PLANNING APPLICATION REPORT

REF NO: A/157/10/

LOCATION: Clayton
The Avenals
Angmering

PROPOSAL: Side extension (Resubmission following A/89/10)

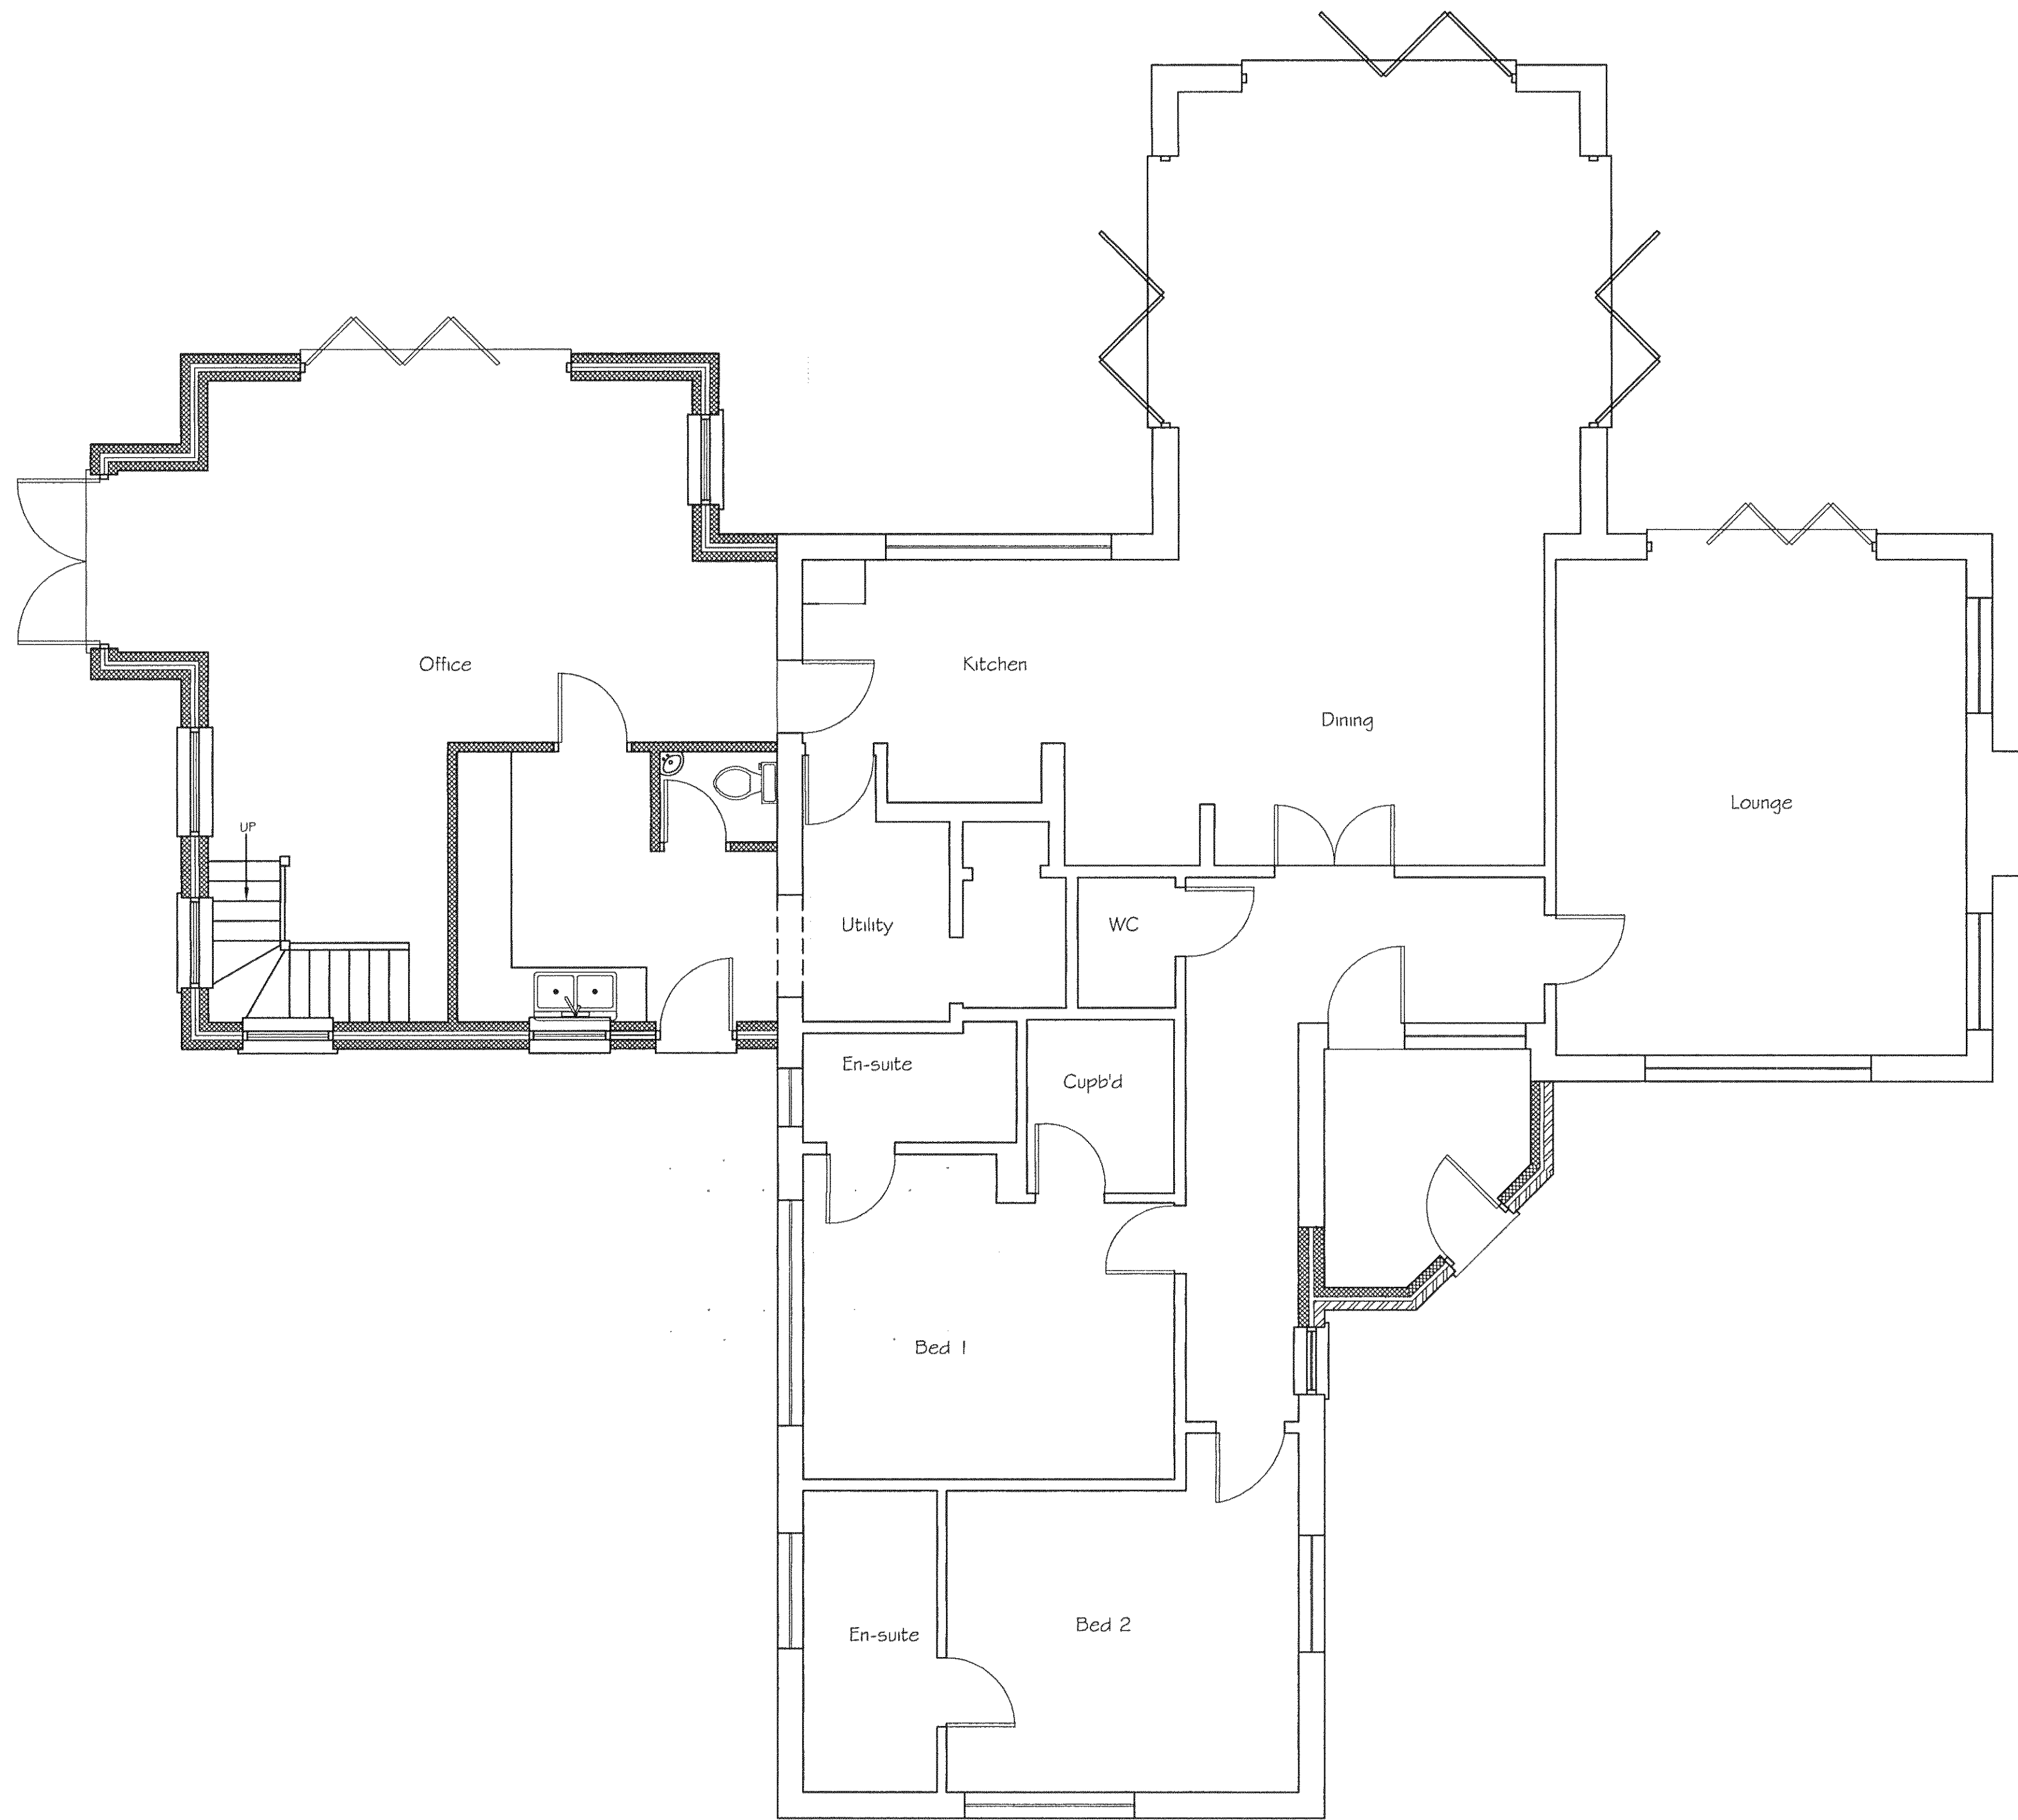
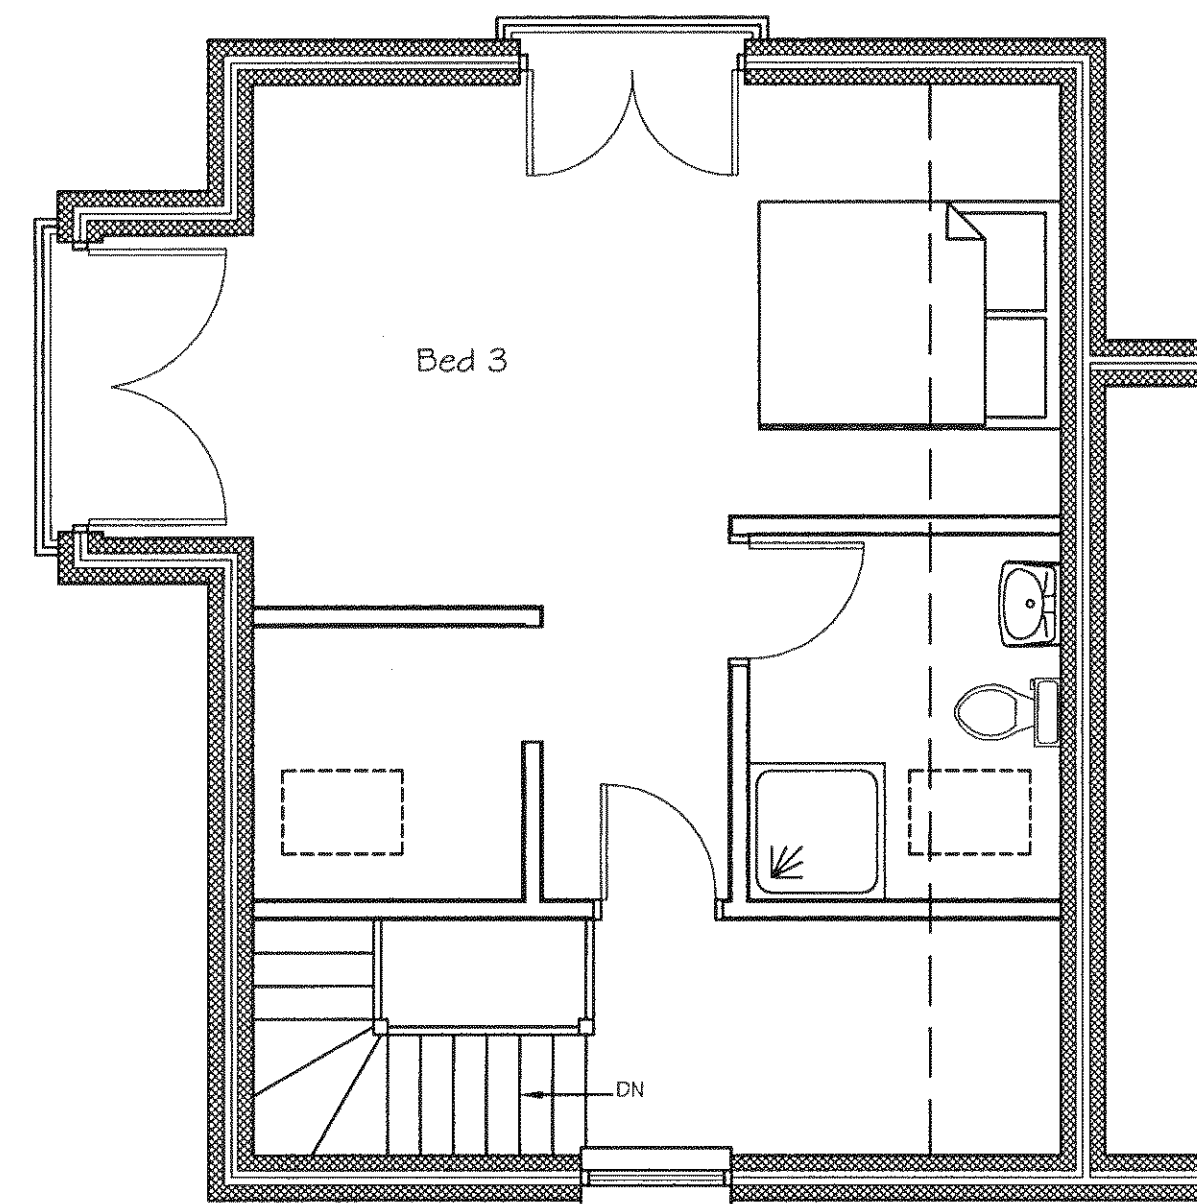
No objection but it is unclear whether the office is for commercial enterprise or home study as this is not stated.

The office can be accessed from the existing dwelling and would appear to be intended for use by the householder. In any case, a condition will be attached to any given approval restricting the use of the extension to that incidental to the existing dwelling.

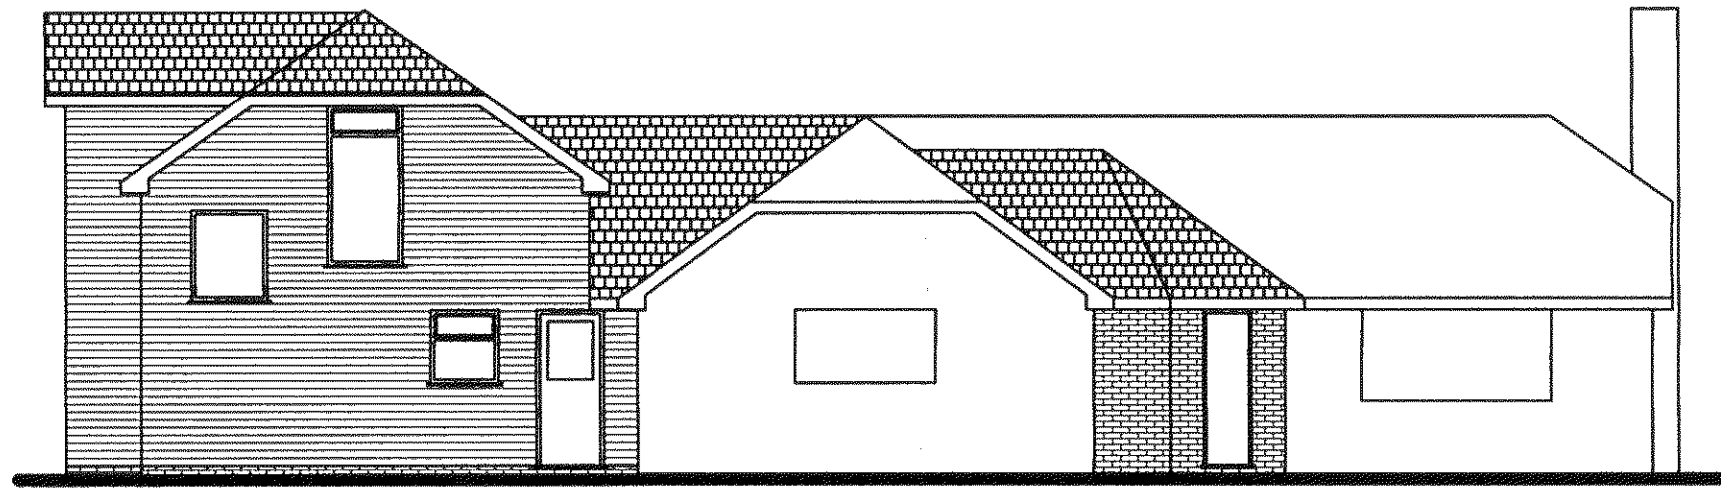
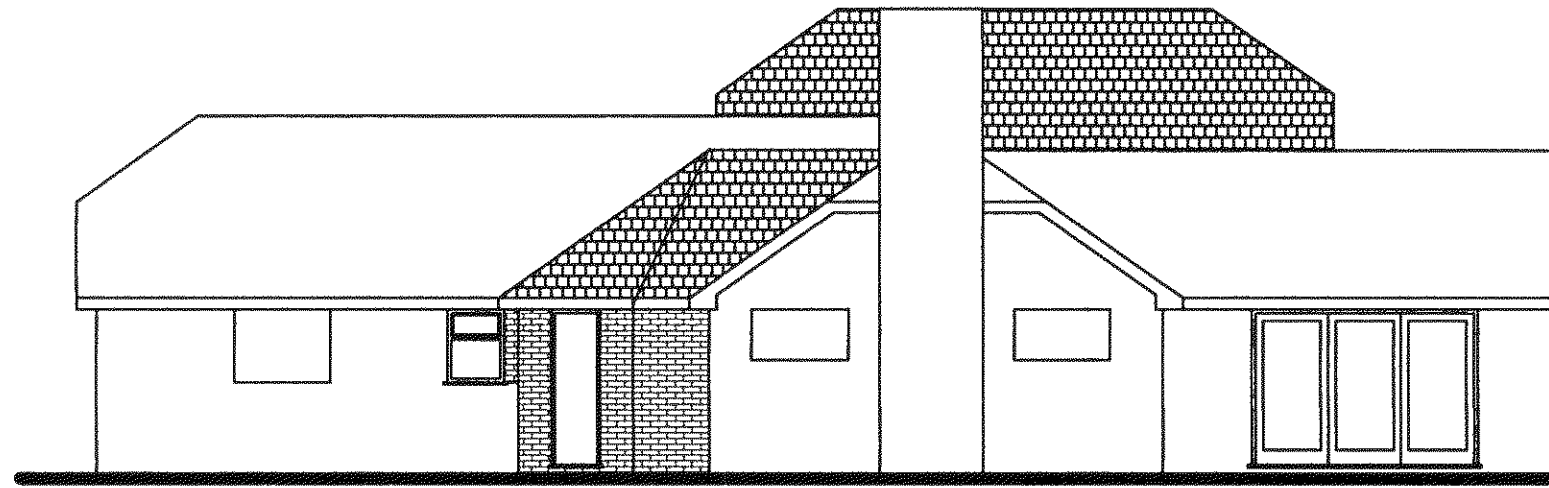
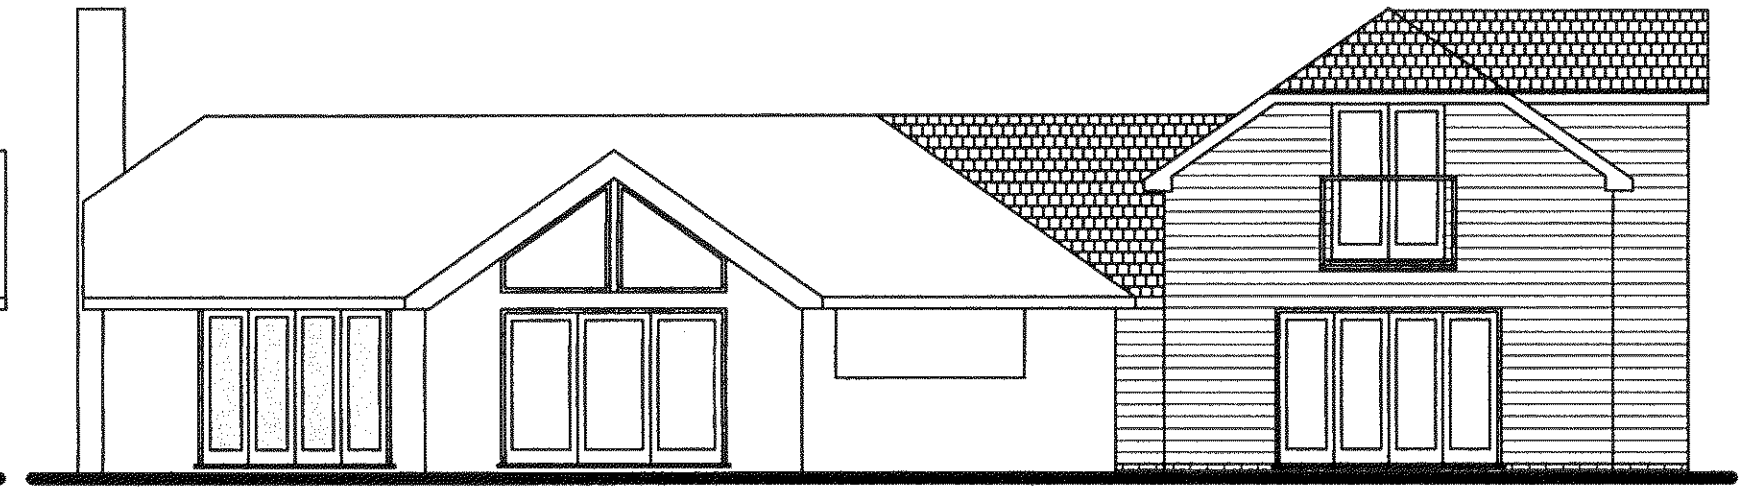
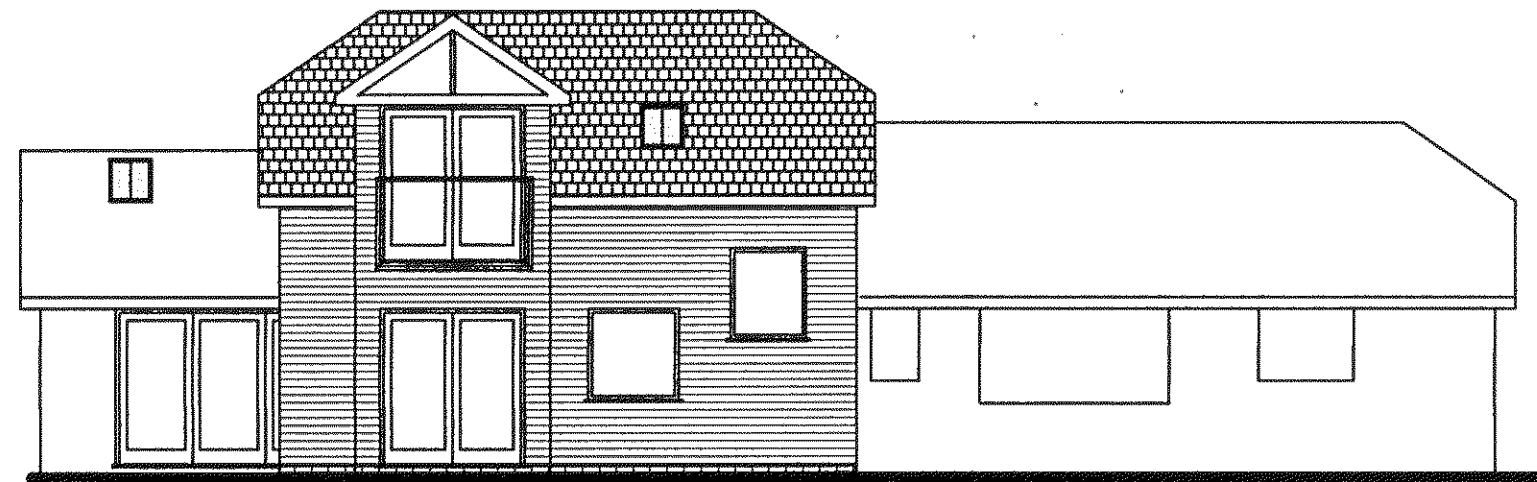
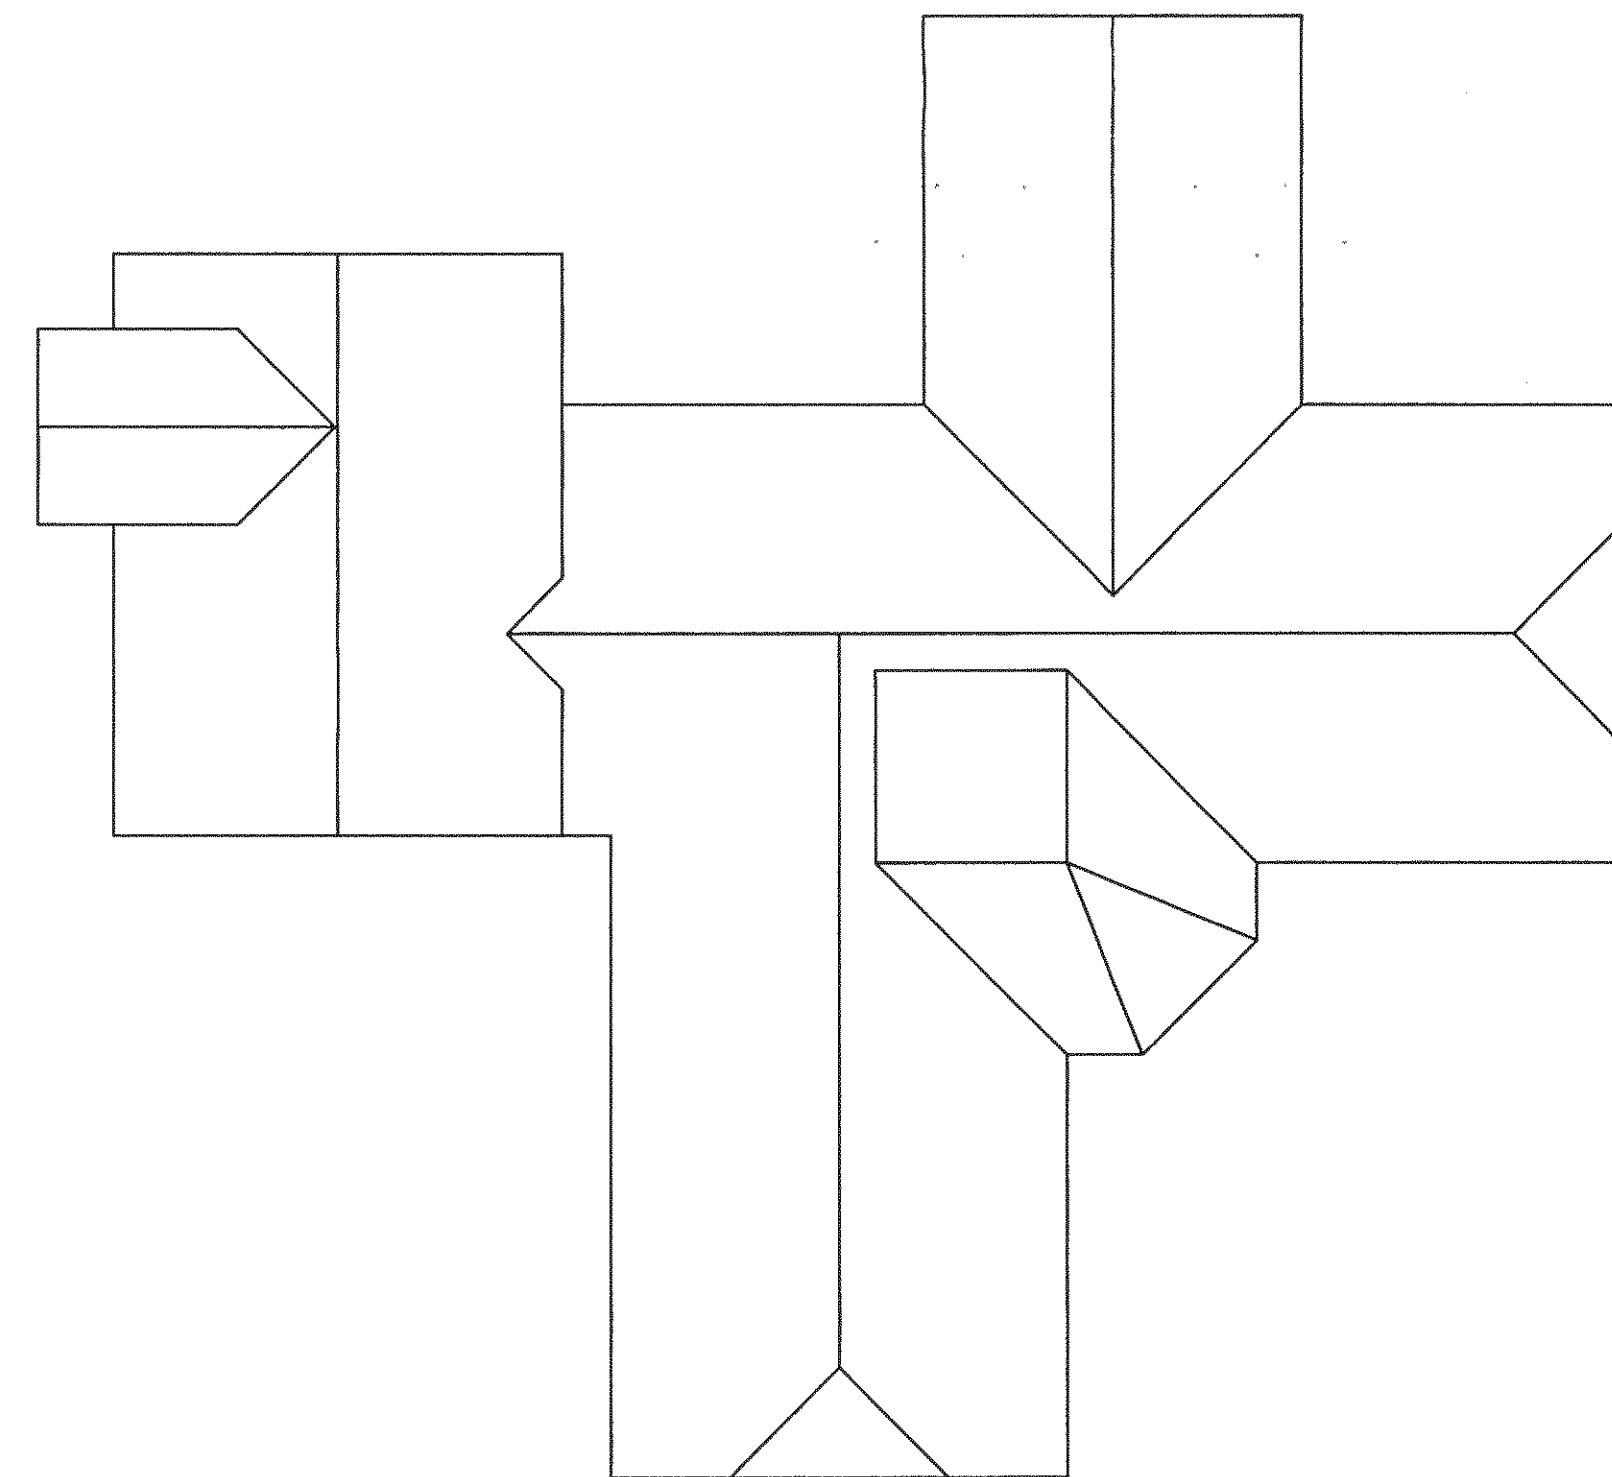
The two-storey proposal is considered to conflict with relevant Development Plan policy DEV19 in that it would not relate sympathetically towards the existing dwelling in terms of design, form or scale and would not be visually subservient to the existing bungalow dwelling.

The proposal has attempted to address concerns raised by altering the form of the roof of the extension from a gable end to a sussex-hipped shape, which reflects the form of the roof of the existing dwelling. A slight reduction has also been made to the height of the extension. However, it is considered that a two-storey extension attached to the existing bungalow dwelling would fundamentally appear unsympathetic towards it and, despite the alterations in design that have been made, it is considered that the proposal relates unsympathetically towards the existing dwelling, its greater height meaning it would not maintain visual subservience to the bungalow and would appear awkward when seen in context with the existing dwelling. The roughly cubic dimensions of the proposed extension would also conflict with the rectangular existing dwelling, and this would further harm the relationship between the two features.

- 1 The proposed extension would not be visually subservient towards the existing dwelling, leading to an awkward and poorly integrated appearance and is thereby in conflict with policies DEV19 and GEN7 of the Arun District Local Plan.
